2022/1179

480 Burton Road, Monk Bretton, Barnsley, S71 5RU

Single storey attached garage extension to side/rear and formation of external staircase to access existing cellar with associated safety rails

Drawing Title
SITE PLANS

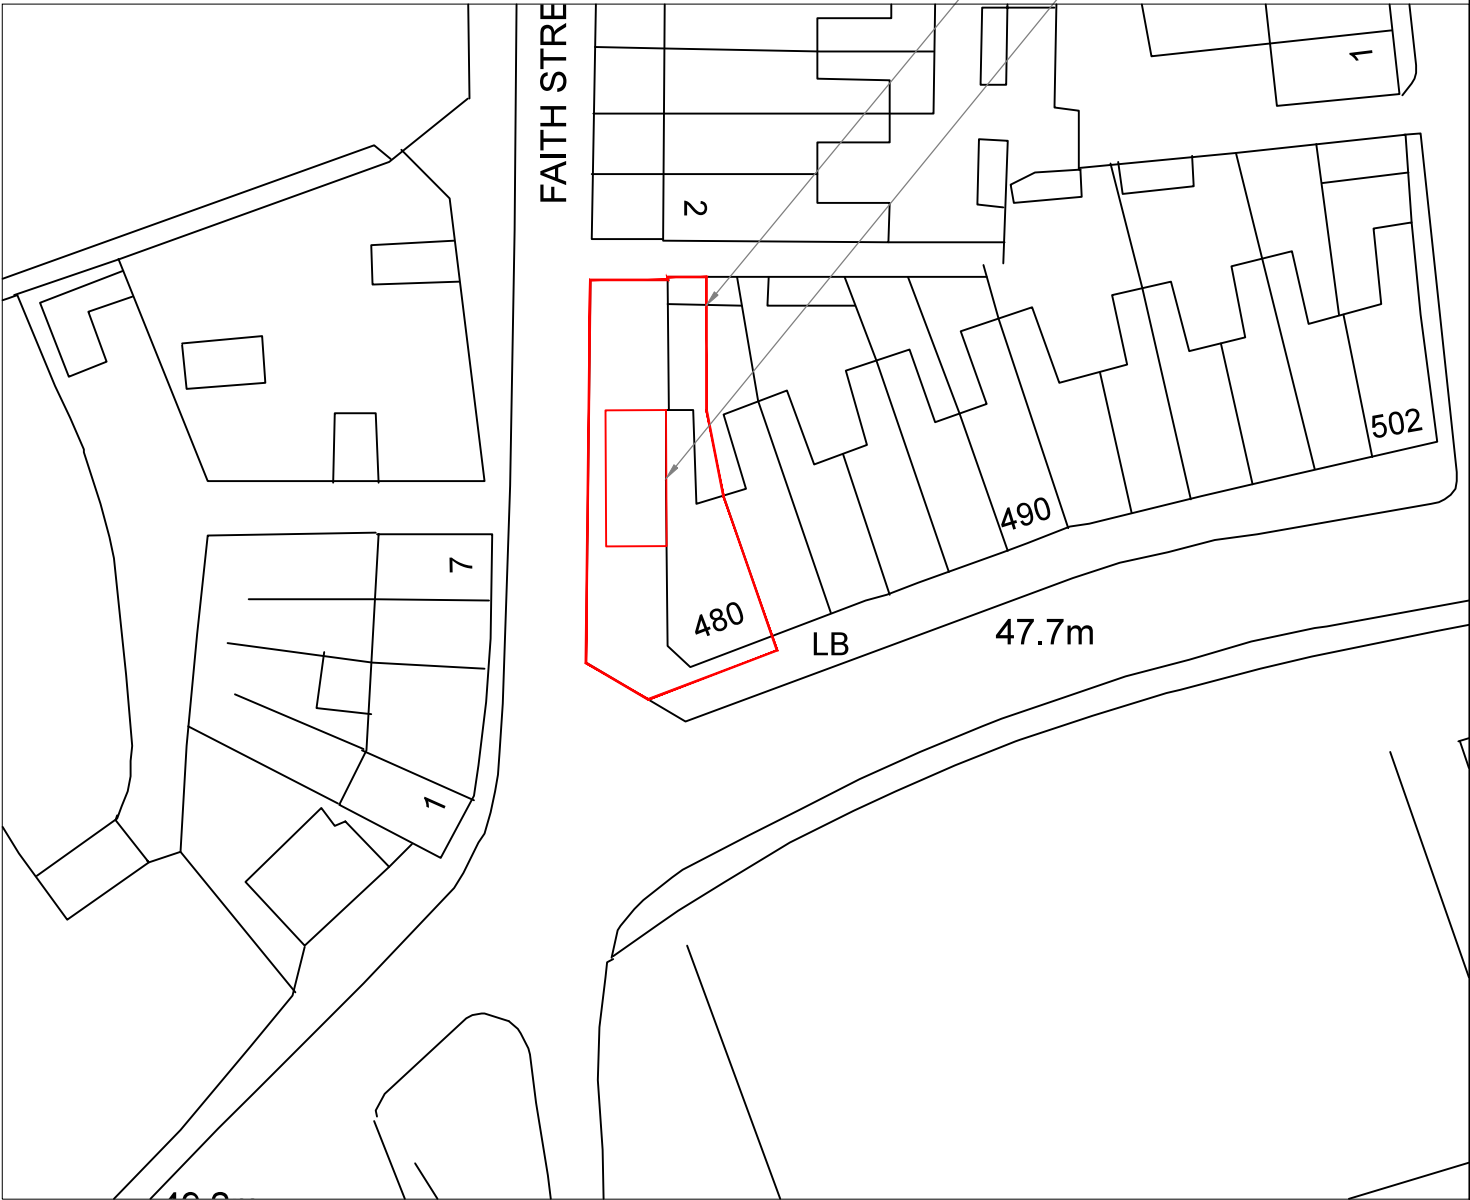
There will be no impact upon highway safety. The proposed garage has adequate internal dimensions to qualify as a parking space. The proposals do not result in the loss of any off-street parking provision. It can be seen from the proposed layout plan that the new stairs/railings project across the garage opening, however, an adequate 2.5m access width is maintained. It is considered that the proposals do not adversely impact upon the highway.
